Online Comment

Application H16-0682-26
Location The Hollies Farmyard Pilmore Lane Fulney PE12 6EG
Proposal Erection of 4 no. dwellings, change of use of existing packhouse to a single dwelling and demolition of agricultural buildings.

Name Ruben Lopez Catalan
Address Lincolnshire County Council, County Offices, Newland, Lincoln LN1 1YL
LN1 1YL

Date Submitted 27-08-26
For/Against Comments

Drawing No. 1623-3_FP_GA03	Rev -
--------------------------------------	-----------------

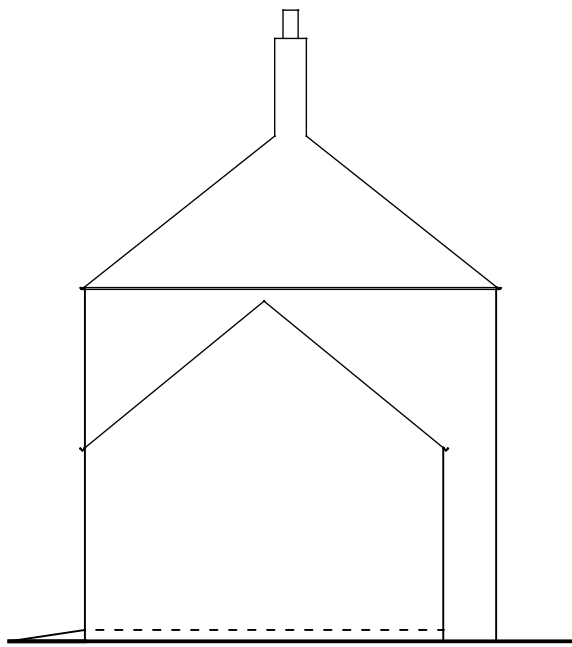
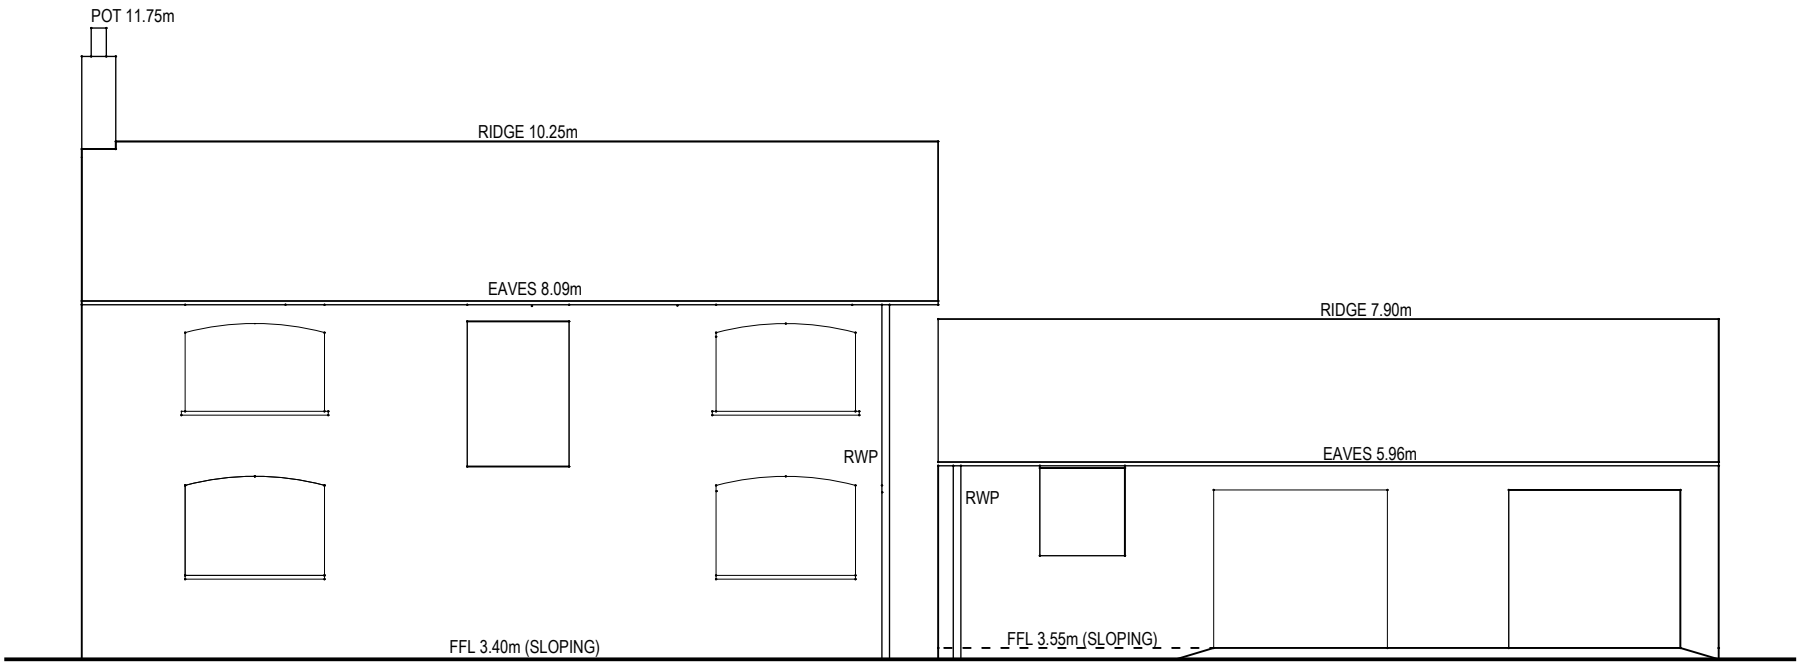
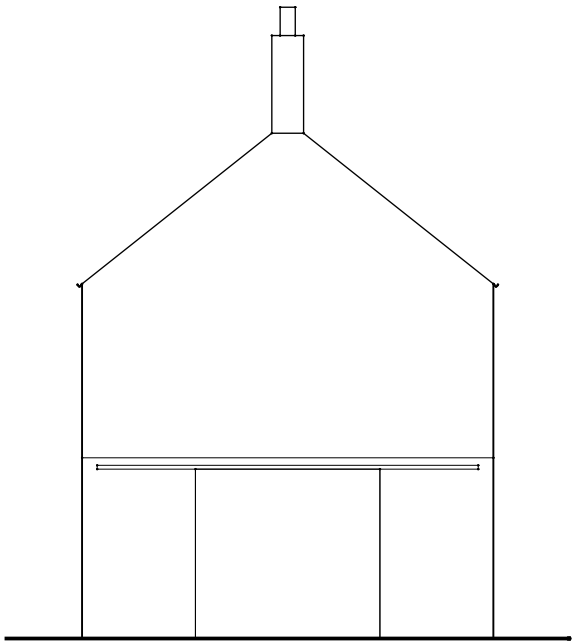
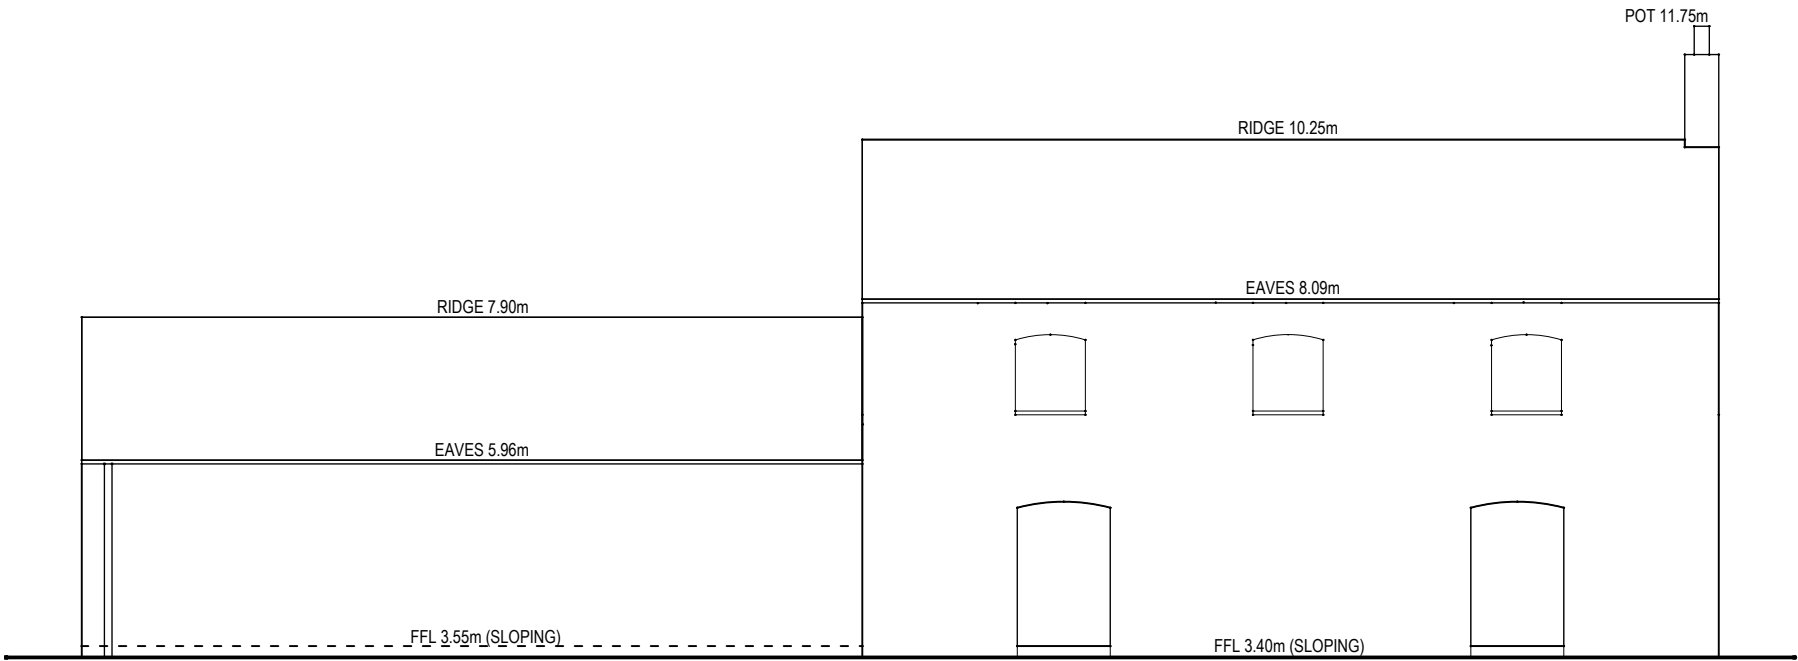
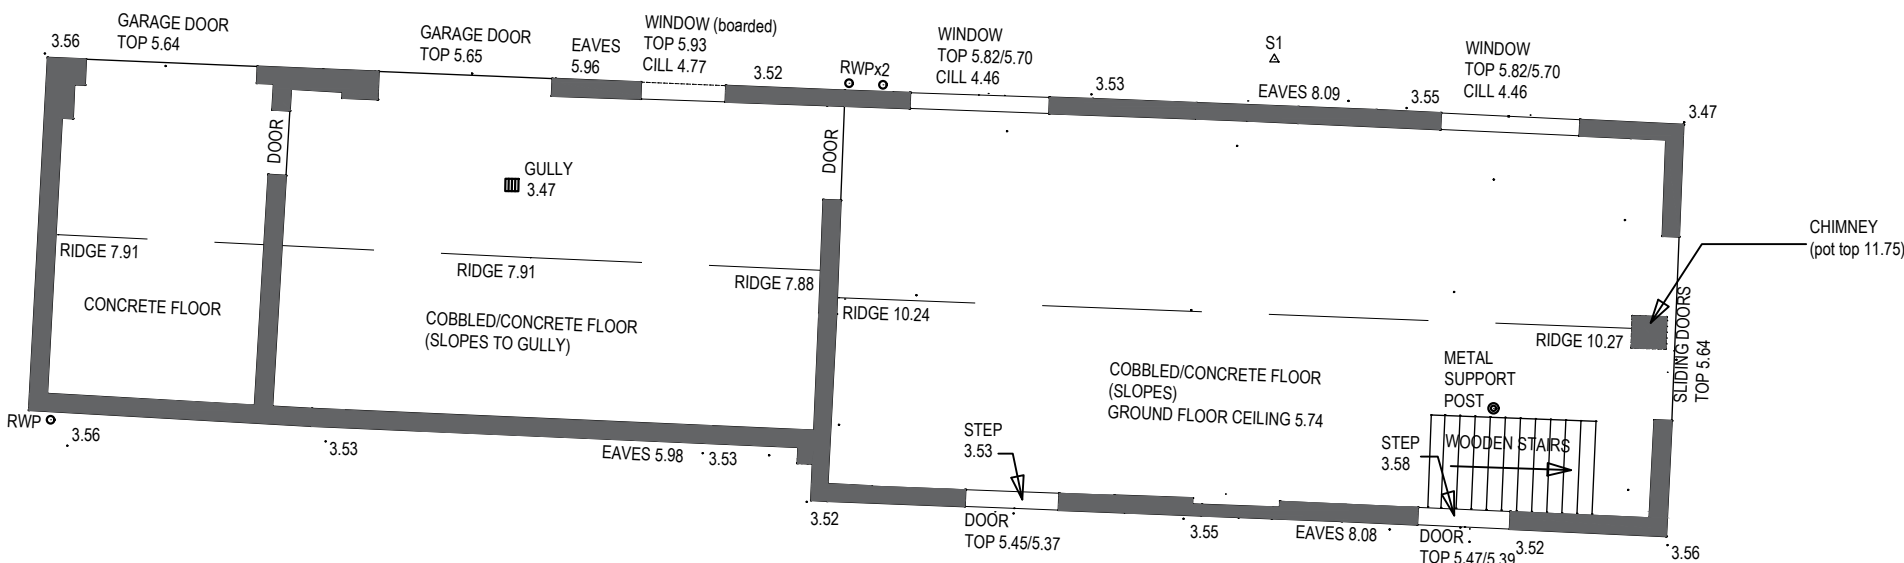
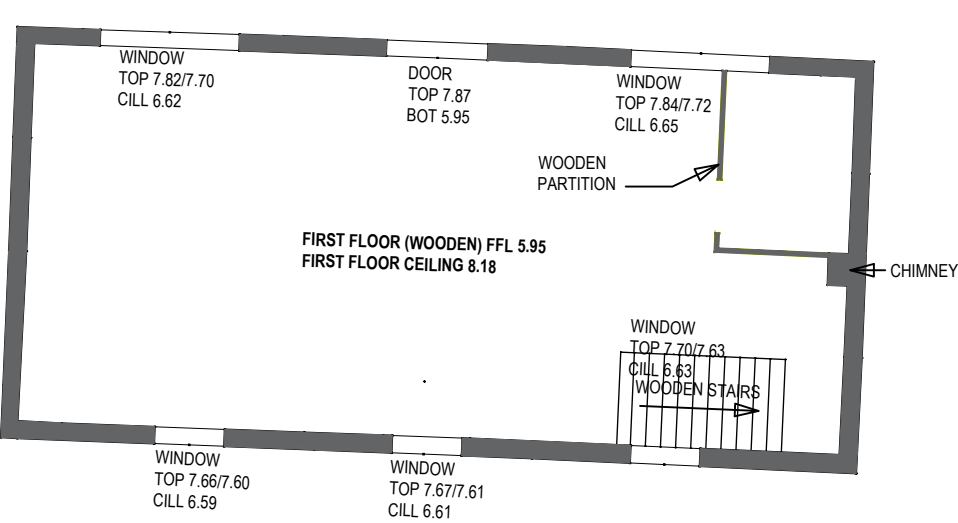
This will comprise a phased programme of recording including, but not limited to, a level 3 historic building recording of the agricultural building subject to the change of use, in accordance with Historic England's document 'Understanding Historic Buildings: A Guide to Good Recording Practice'.

This will enable the agricultural building (Building 3 on dwg no. 1623-3_FP_GA03) to be recorded prior to the change of use.
